Site Plan Application / Supplemental Submission
22 Bramhall Street
CBL 53-D1,2,7;CBL 53-E1,2,10,13;CBL 53G-1,13;CBL 54-H-1;CBL 64-C1,2

Maine Medical Center is pleased to submit the following responses and updated materials to assist your review of the Bean 2 Roof Addition Site Plan Application. These responses are based upon continued review by staff. As you are aware we have submitted twenty six (26) exhibits/ tabs to date, therefore, this submission adds new exhibits/ tabs as noted herein:

D4 OVERALL NORTH ELEVATION
 1/8" = 1'-0"

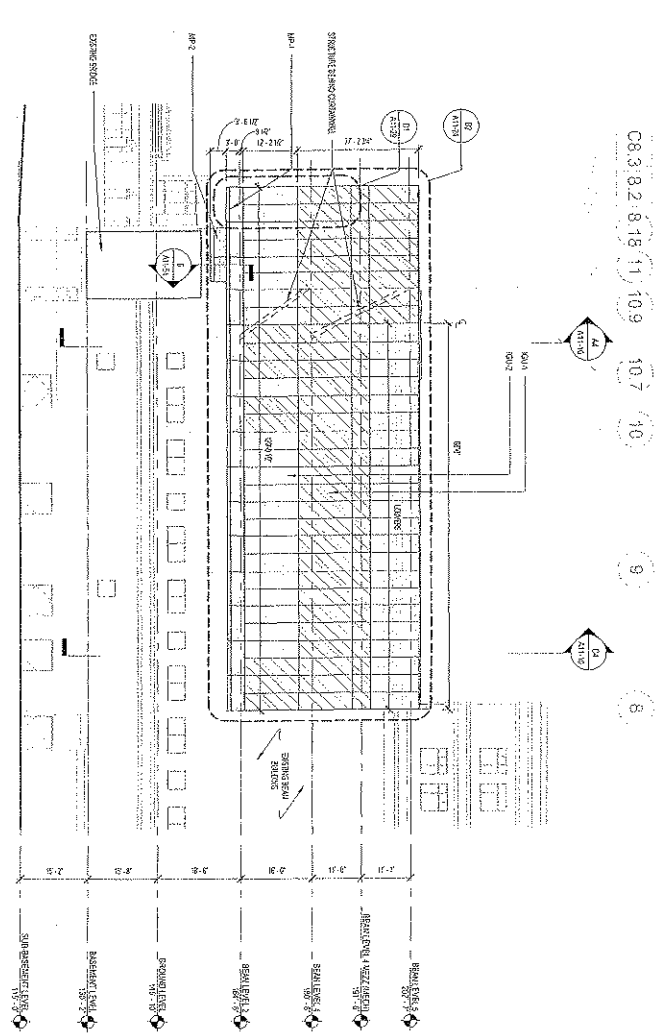
Rendering that shows reflectivity of louvres and metal panels (accurately in comparison with the glass/fritted glass) on the north elevation.

The new metal panels will match the existing panels installed on the East Tower. MMC would be happy to arrange a site visit for the City Planning Board members and/or staff to review this material. Perkins + Will, project architects, will be bringing a sample of the metal material as well as fritted and spandrel glass samples to the Public Hearing. We believe that these approaches will provide a more accurate representation of the materials being used than any rendering could achieve.
